PLANNING CONSULTATION RESPONSE

Application No	2025/0908
Proposal	Re-engineering and Restoration of Yew Tree Quarry through the importation of non hazardous Excavated Soil Materials
Address	Stairfoot Brickworks, Wombwell Lane, Stairfoot, Barnsley, S70 3NS
Date of Consultation Reply	19/11/2025
Consultee	Katie Lawrence, Planning Ecologist

Figure 1A- Breeding bird survey results for 07/04/2023

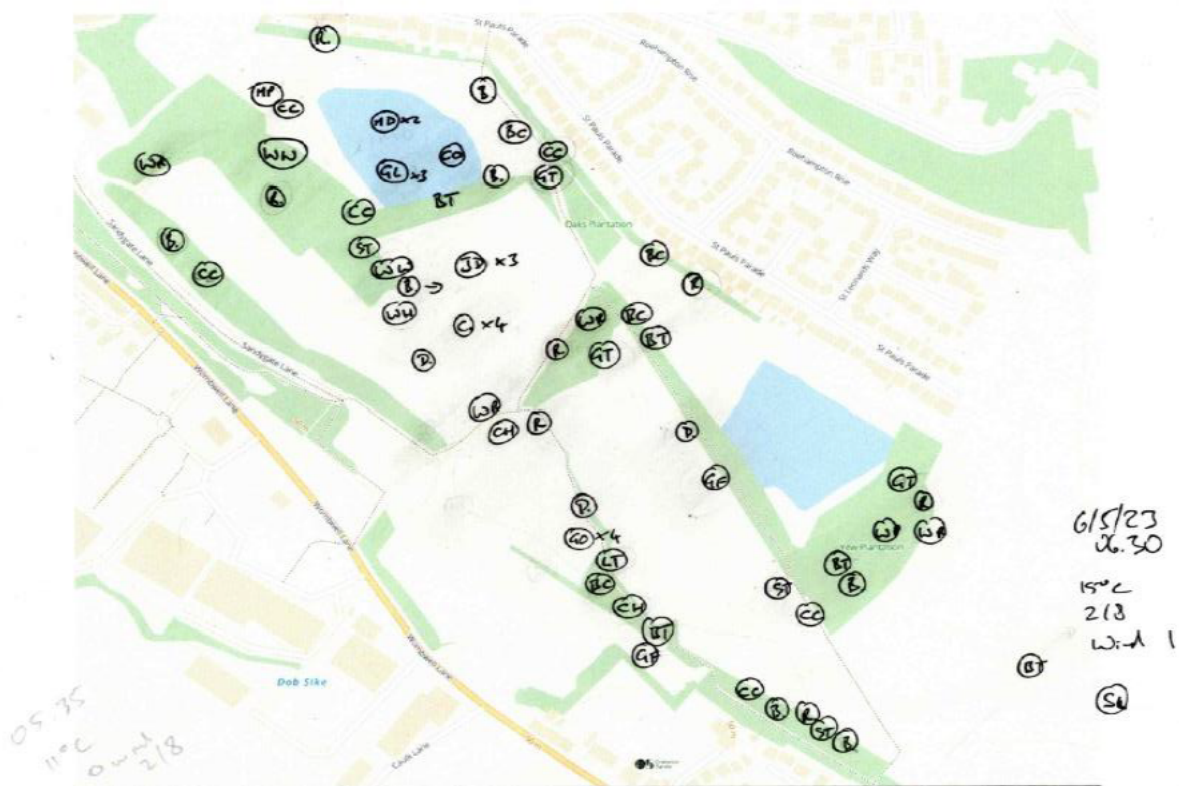
- The report details that skylark was recorded within the site during three of the four survey visits. Is this within the red line or blue line boundary as it is not clear on the survey maps provided within the appendix? A bird recorded to the south-east of the survey area has a code SL; however, this code relates to swallow rather than skylark. This should be checked and amendments made, where necessary. The maps would ideally be digitised so that it is clear as to what species were recorded, as it is currently difficult to decipher.
